Subject: RE: amendments to B3/B5 access road North Littlehampton

I write to confirm acceptance of your Drawing A/PHLITTLE.2/IDR-GA Rev 'G' (as amended) with the additional visibility splays for pedestrians and cyclists at the formal junctions, for planning purposes. I also confirm acceptance of the landscaping proposals as shown on this drawing. Neil Crowther will advise which planning application(s)/condition(s) this satisfies.

Tim Townsend | Senior Planner, Planning Applications - Strategic Development, West Sussex
County Council

PROPOSED S278 HIGHWAY WORKS
AMENDED IDR GENERAL ARRANGEMENT DRAWING

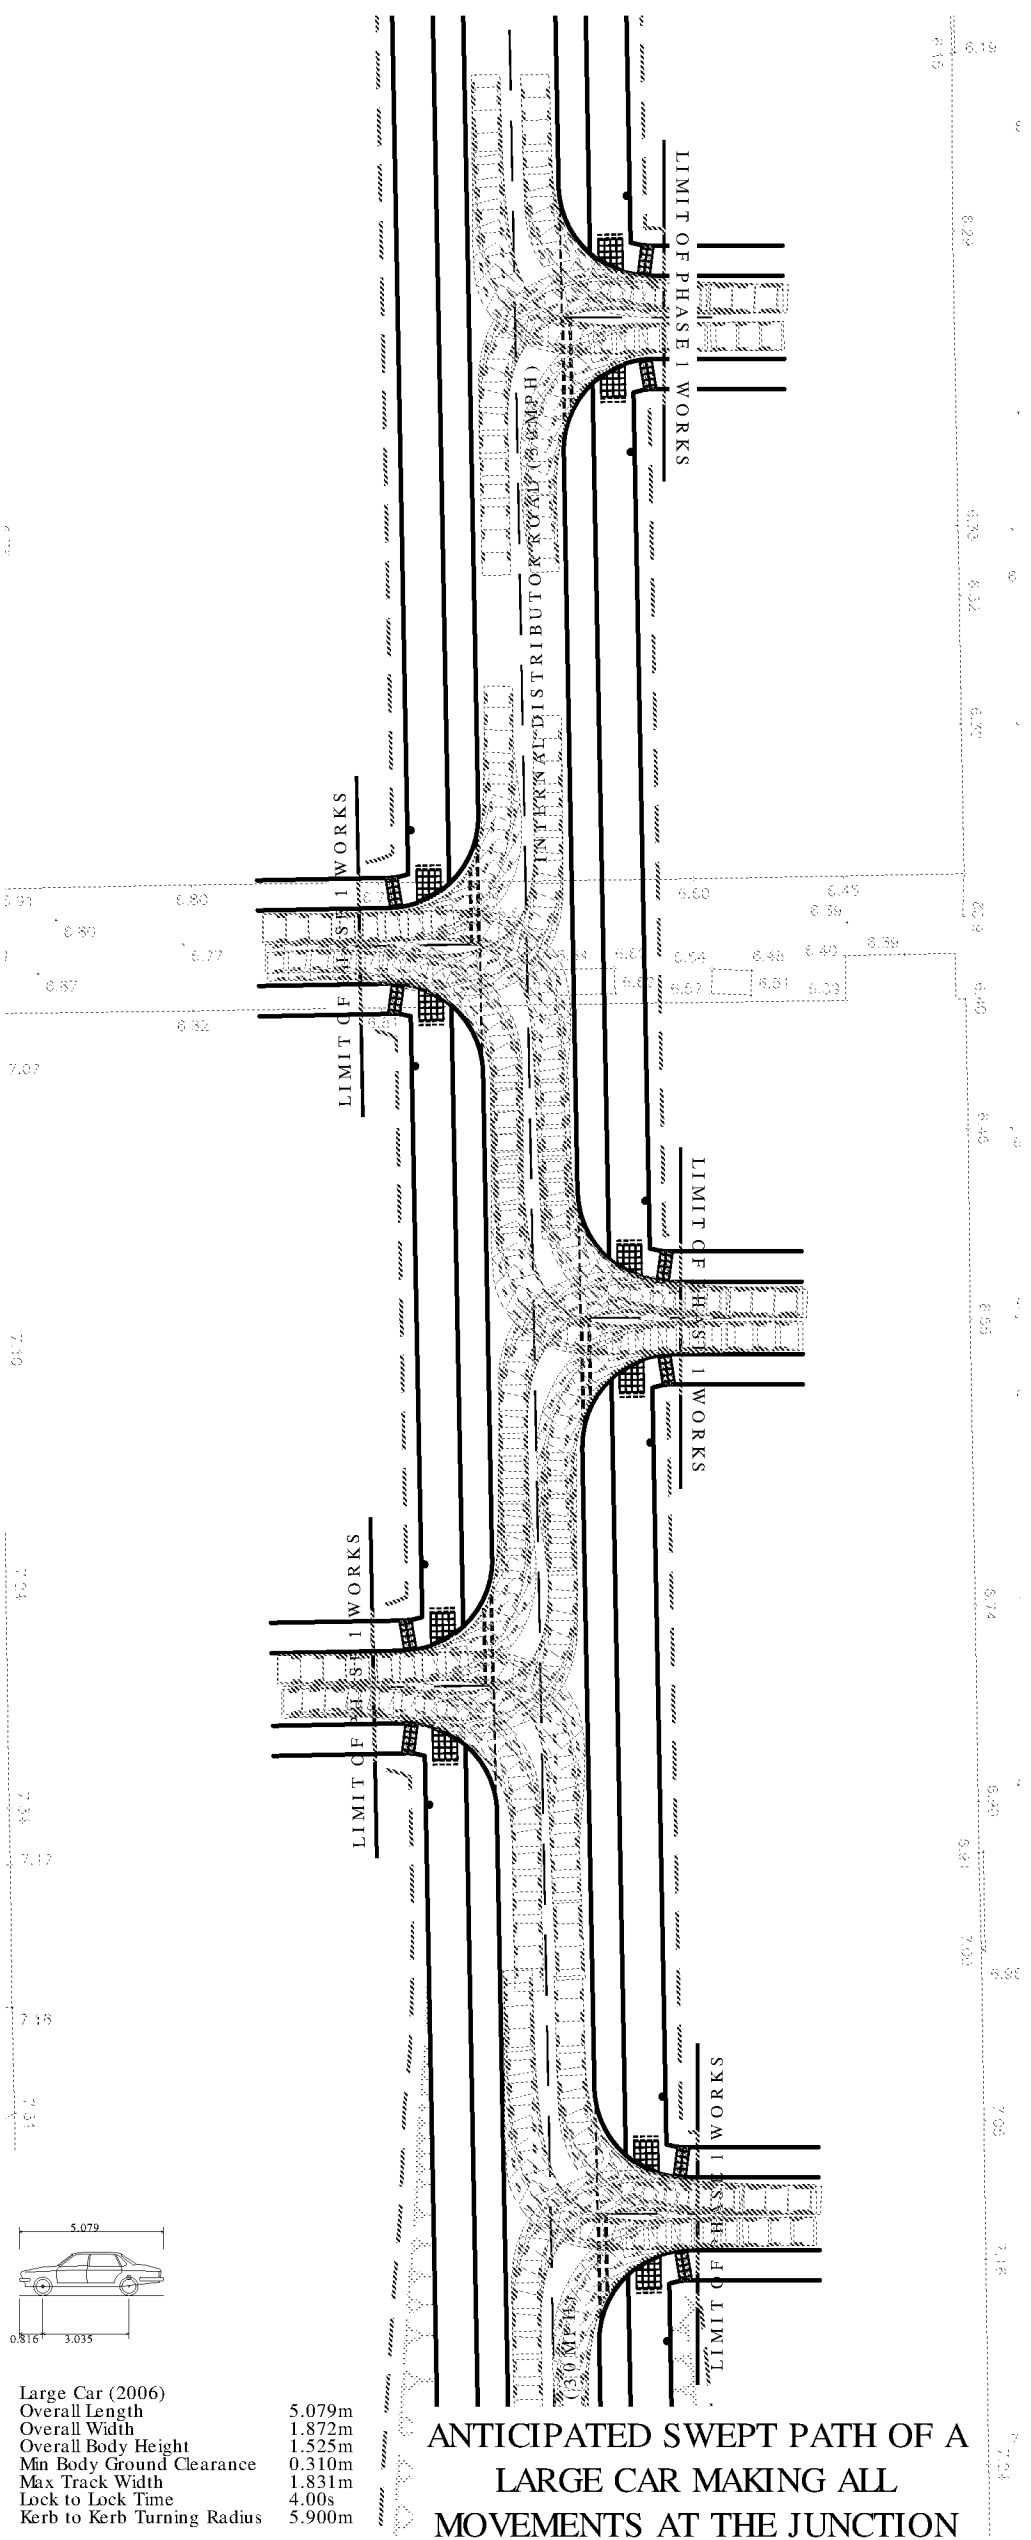
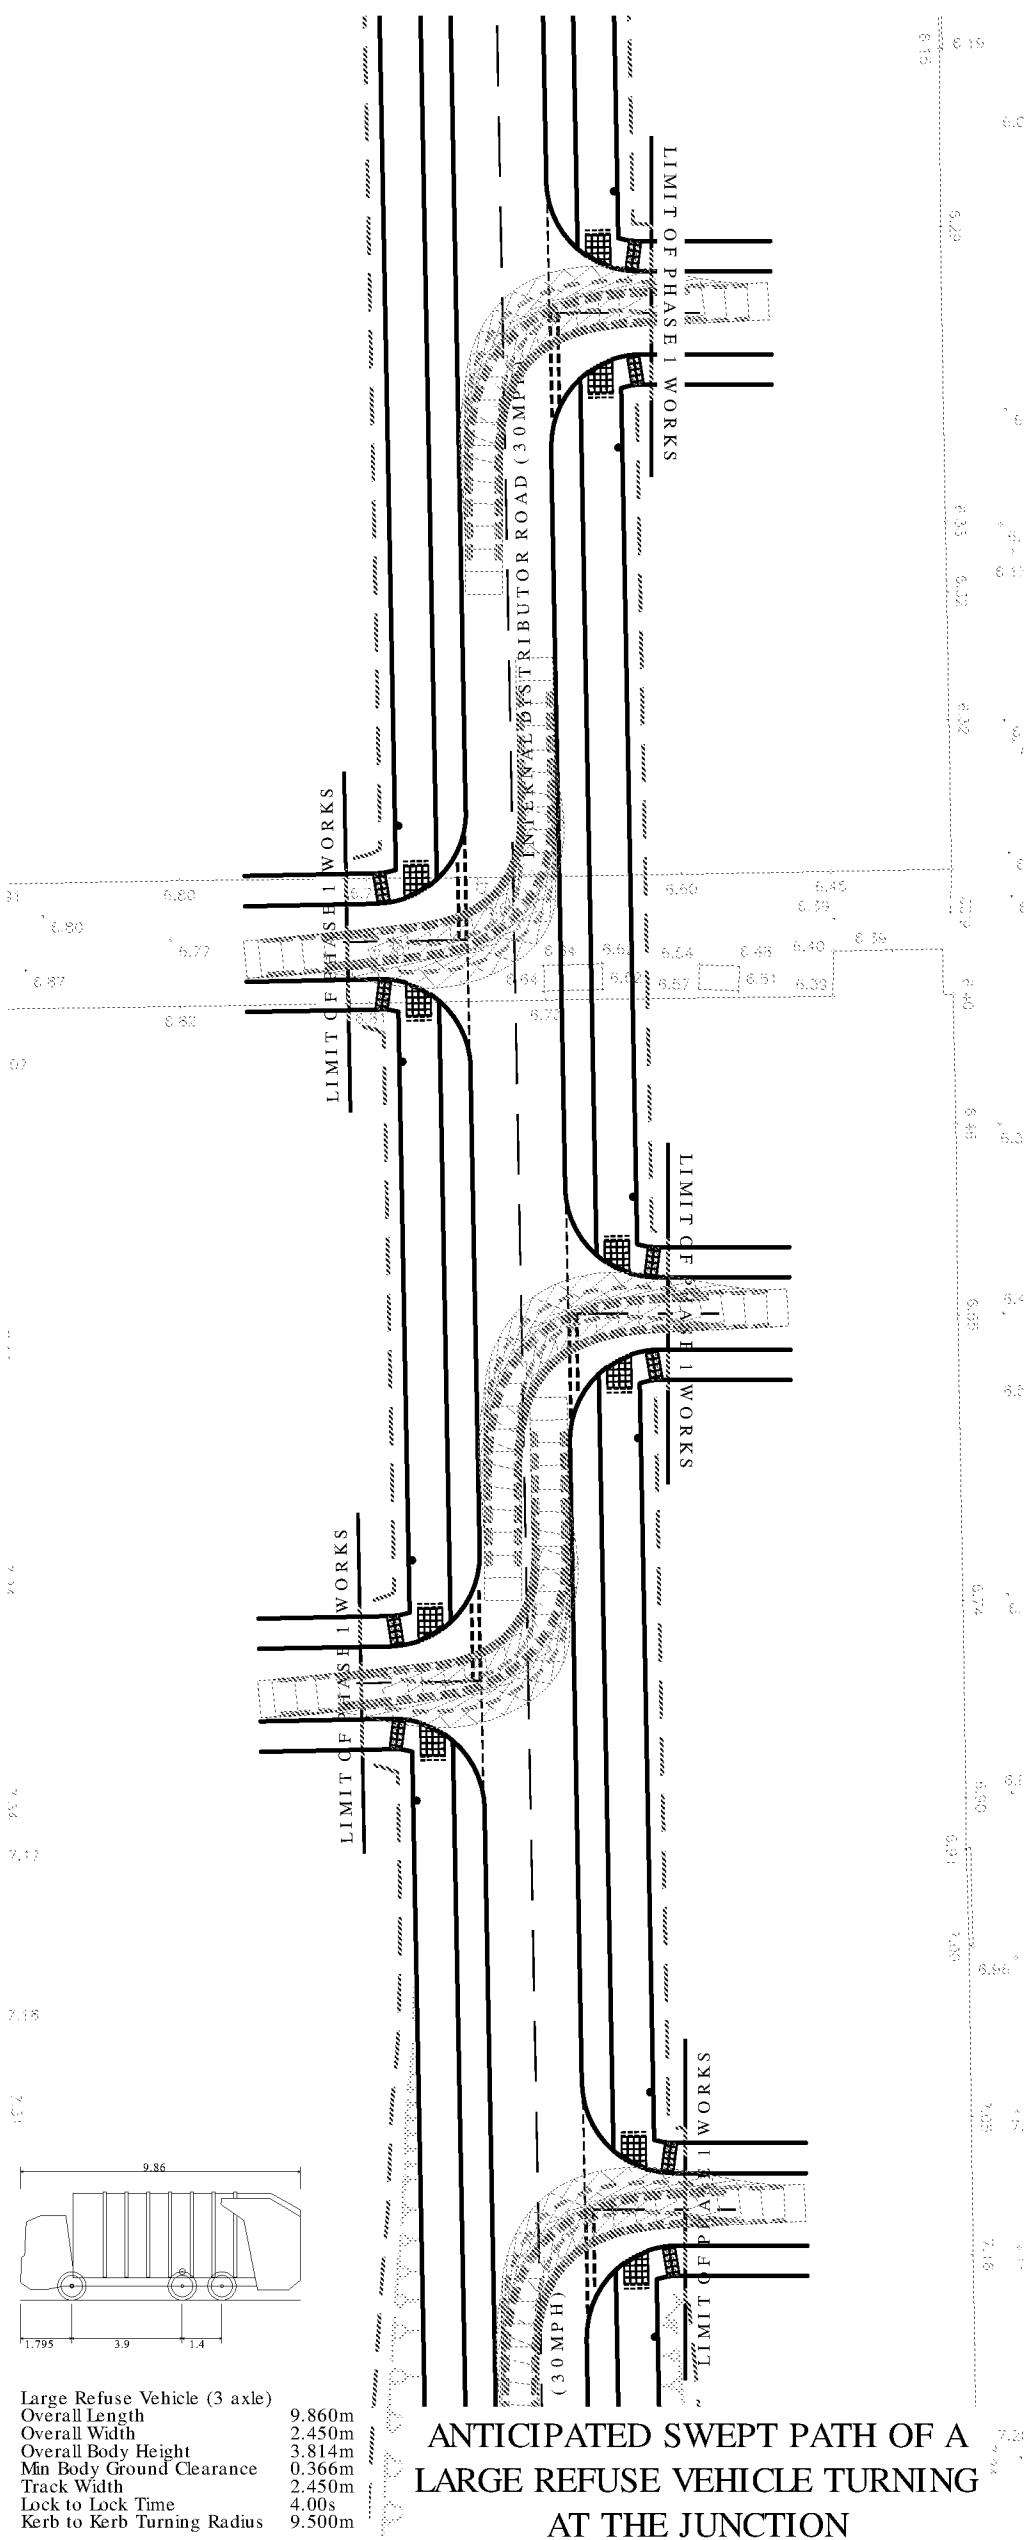
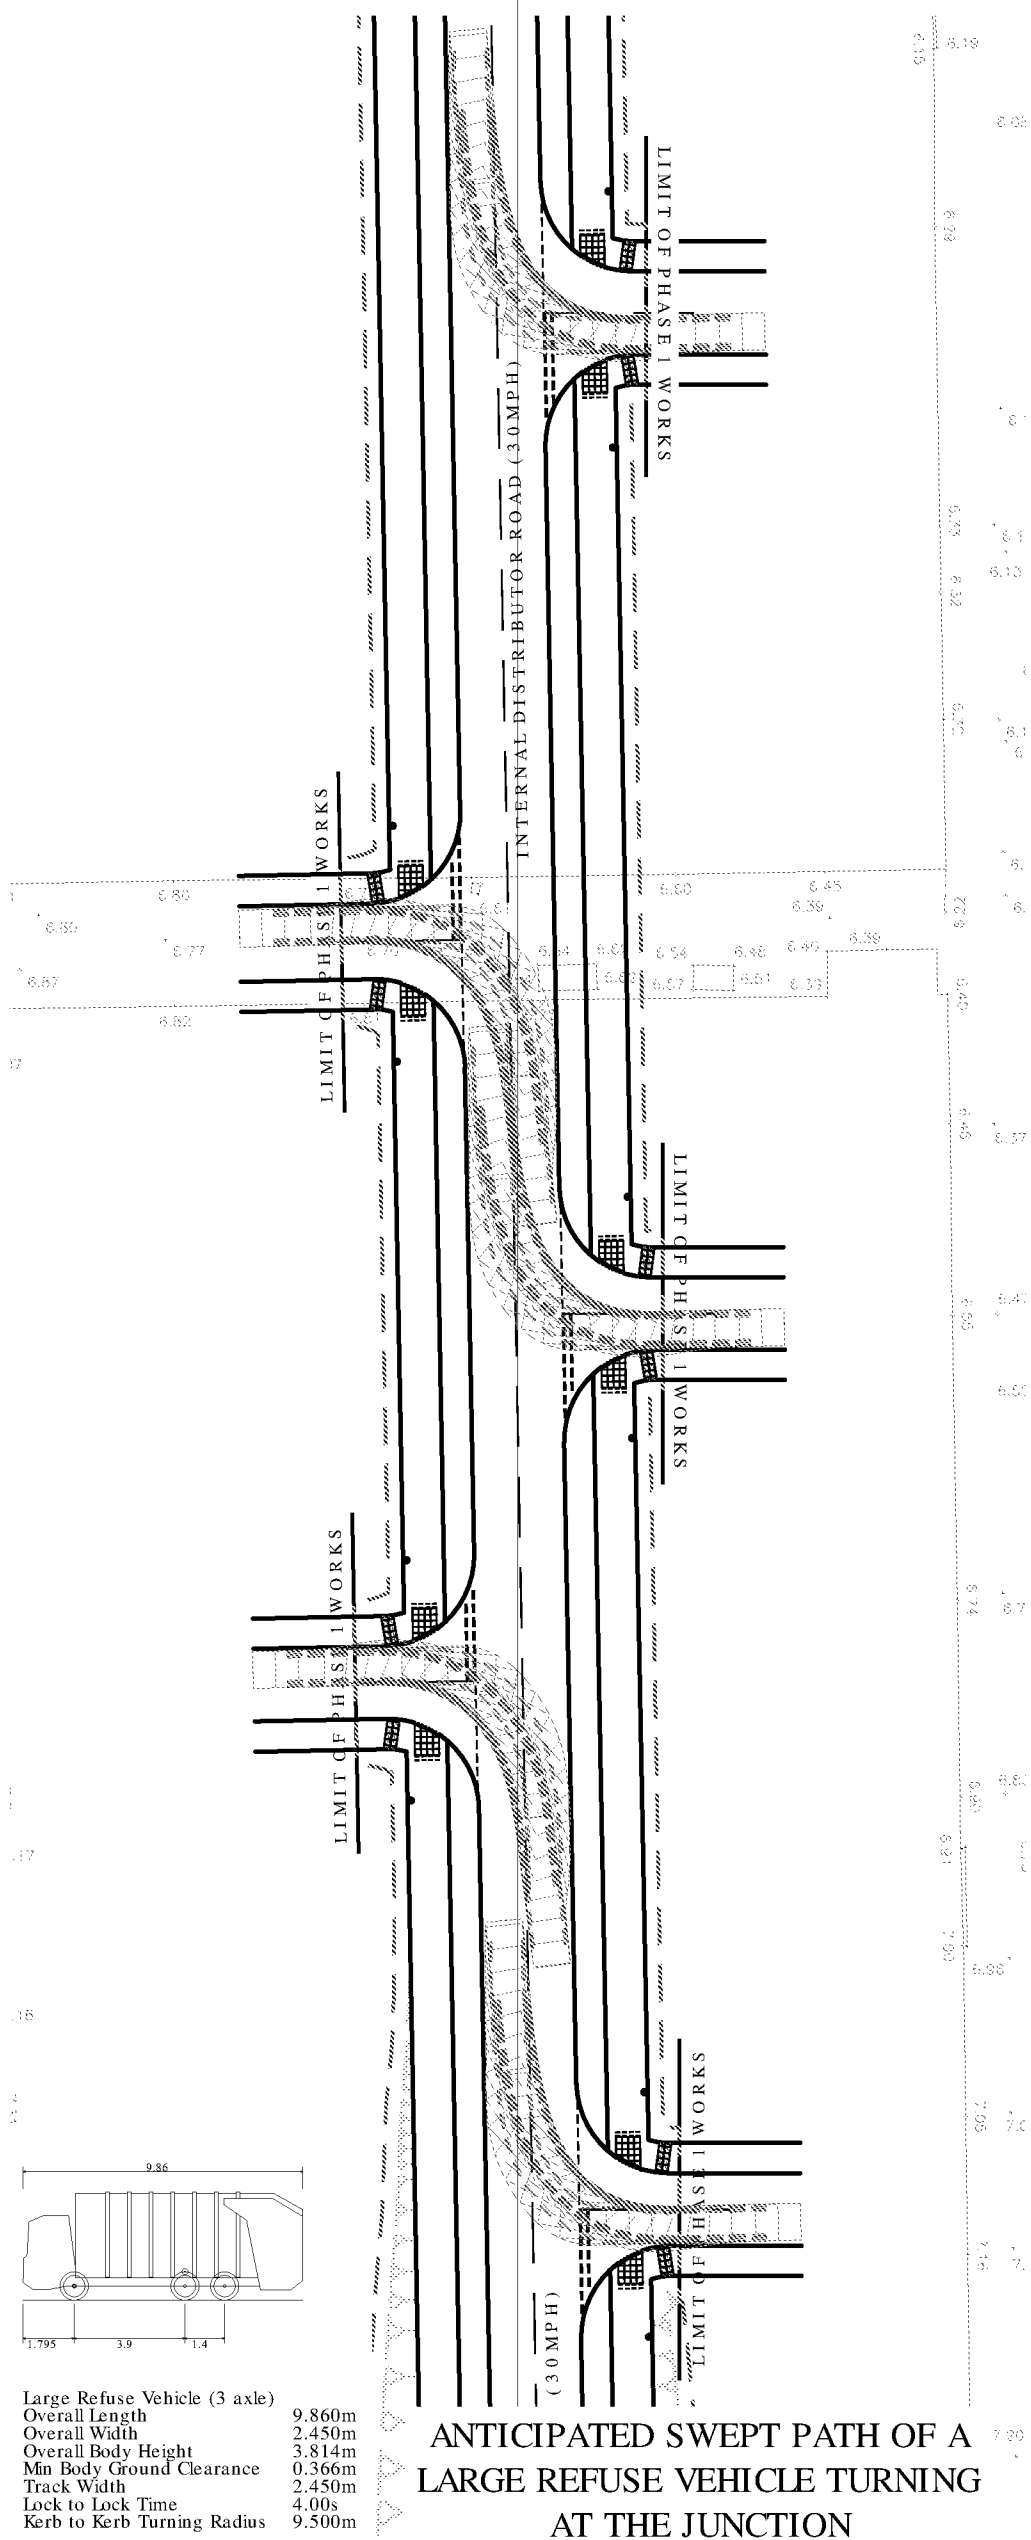
3. Achievable Cycle intervisibility splays based on min 1m back from the channel line; Your plans show visibility from the crossing points. What we require (in addition to what you've shown) are splays across the corners of the plots so pedestrians and cyclists are intervisible to one-another. The guidance contained in the LTN and TD documents is often difficult to interpret. Therefore, taking a practical view of the situation we are of the view that 2.4m x 2.4m splays should be shown across each plot corner adjacent to the formal junctions with maximum height of any walls, fence and/or planting being 0.6m in these areas. This is based on the assumption that cyclists will be slowing for each junction which will bring their speed down, giving both user types a reasonable degree of intervisibility at these points. Of course, the remaining boundary treatments for the properties fronting the north-south road should be no higher than 900mm. Please see my sketch on the attachment to aide you for the junction corners.

A considerable number of trees is shown within the verges on both sides of the IDR, some of which are within designated junction visibility splays.

Whilst we note that the trees are intended to be of relatively small girth and have clear stems, they will inevitably have some impact on sightlines; this effect will be greater the closer they are to the junction and will increase with time as the trees grow. This will increase the risks of vehicles emerging from the side roads being struck by passing traffic, and of cyclists approaching a junction along the shared path being concealed from drivers intending to turn into the side road.

Do not plant trees within the visibility splays.

The crux of the issue contained in the summary above is the section I have highlighted. Any risk is of course greater in the leading traffic direction at the junctions because traffic is on that side of the road, although there is still risk in the trailing traffic direction – albeit perhaps less-so because vehicles would in normal circumstances be on the opposite side and more intervisible as a result. If you want to retain the trees, you will need to demonstrate that sufficient visibility is available for the prevailing conditions and the types of users expected. What can you do to the design that avoids losing trees? Is it possible to re-locate the first/nearest tree to each junction in the *leading* traffic direction – perhaps moving them further away and ‘opening-up’ the visibility ‘envelope’? Would that satisfy the Audit Team? Please put this to them for their reply. ***Neil (Crowther), for aesthetic/planning reasons, would you want the nearest tree in the trailing traffic direction also moved to correspond with the other side of each junction?***

2. **Tree locations and interaction with street lighting requirements** – still awaited from you following your discussions with SSE.
3. **Pedestrian/cycle intervisibility requirements at road junctions** – This is still required.
4. **Tree canopy heights** – The tree type states a 2.1m clearance (base to bottom of growth when mature). WSCC still recommend 2.4m to avoid clashes with cyclists and road users. Please amend.

3 – As requested, please see attached the amended drawing ref **A/PHLITTLE.2/IDR-GA Rev G** amended to indicate the additional vision splays.

1. Updated street lighting layout received from SSE dated 13/5/16;
2. Subsequently amended tree locations to avoid street lighting and maximise sight lines;
3. Achievable Cycle intervisibility splays based on min 1m back from the channel line;
4. Effective visibility splays indicated from 2.4m to a point located in the associated centre of lane based on the trees being planted in the middle of the 2m verge and with a girth not exceeding 60cm, which is the maximum girth as advised by the landscape consultant for a 25 year old tree.

Having looked at your revised plan (A/PHLITTLE.2/IDR-GA Revision E), in our opinion the relocation of the trees further away from the junctions is a worthwhile improvement that satisfactorily addresses the concern we raised in Problem 2.3.

Item 2 – The amended SSE design has been received. The street lighting has been moved forward into the verge to mitigate against the provision of trees. We have also subsequently relocated trees further away from the lighting to assist with this.

Item 3 – Pedestrian/cycle intervisibility at the junctions has been added in orange as requested indicating visibility from the min 1m back from the channel line as described in *Cycling England Design Portfolio B.04 Junction and Forward Visibility*.

Item 4 – We have spoken with the landscape consultant and in relation to encroachment, I am advised by the landscape consultant that “As you can see in the picture below a heavy standard with 2m clear stem is very narrow and won’t reach past the edge of the road/cycleway. The same tree at 25 years old will only have a canopy width of 2.5m only reaching just over the edge of the road/cycleway. At 25 years old it will have a clear stem of over 2.4m.” In consideration of the statement regarding the tree, I assume that a clear stem of 2m is acceptable as the spread of the tree is retained within the proposed 2m verge width. (Photo below)
